From: Zac Denton
Sent: 21 December 2018 09:24
To: [REDACTED]
Subject: R/275/18/HH Planning Permission URGENT

Re your letter dated 19th December, I am aware of the plans submitted for planning permission at 36 The Parkway, Rustington BN16 2BU, and wish to make the following comments.

With regard to your New Build plans, we have now had time to consider them in more detail, and would like to make the following observations.

Proposed Elevations

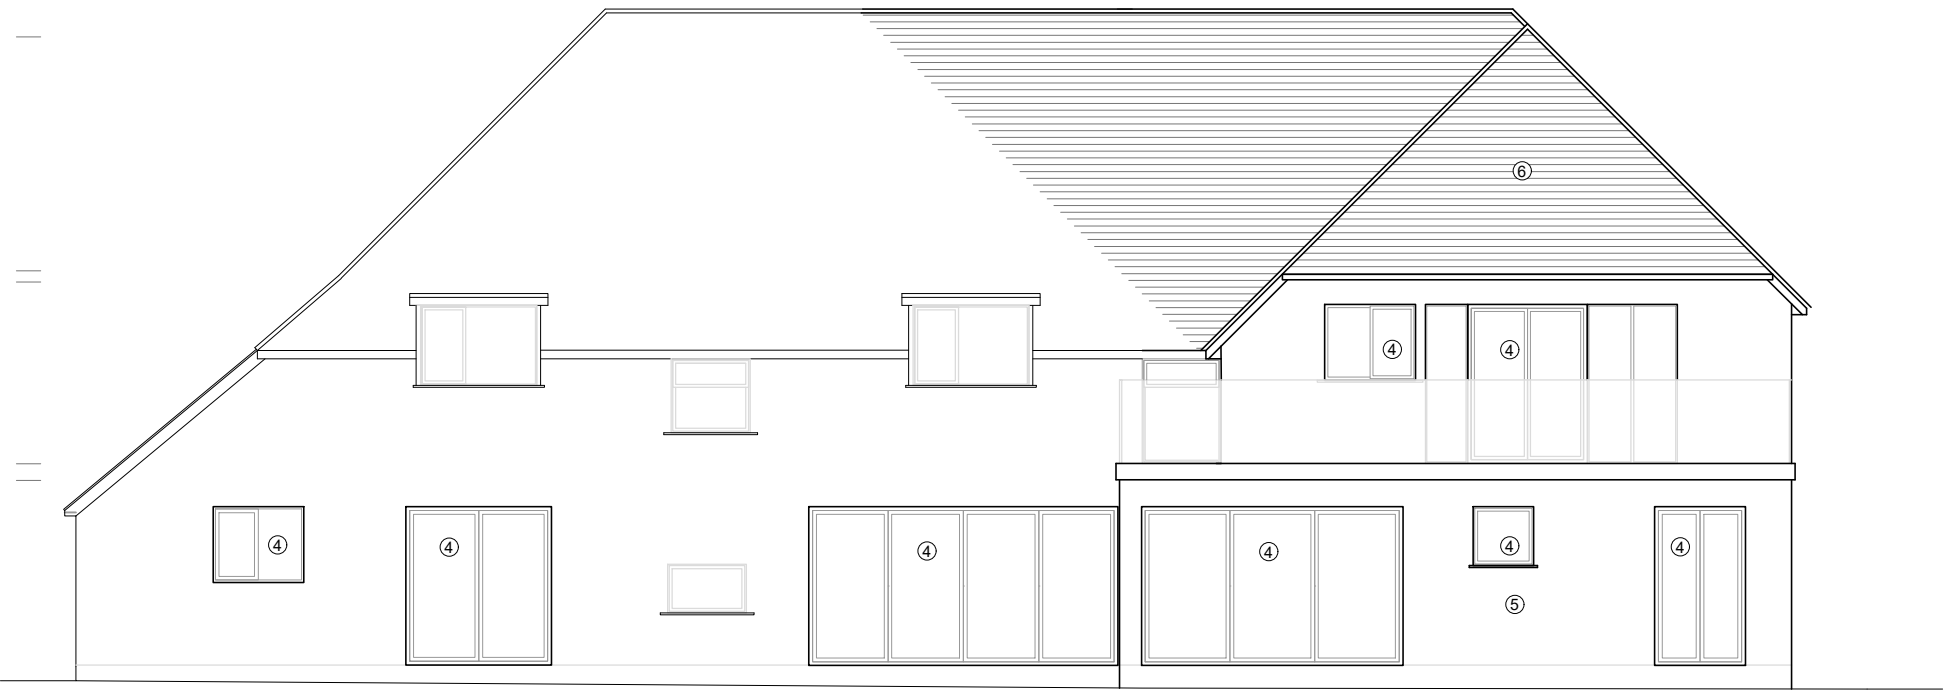
2. Regarding the Return End on your proposed balcony at the rear of your extension, please confirm that this will be either a Solid Wall or Frosted Glass Panel construction to ensure the privacy for both parties.
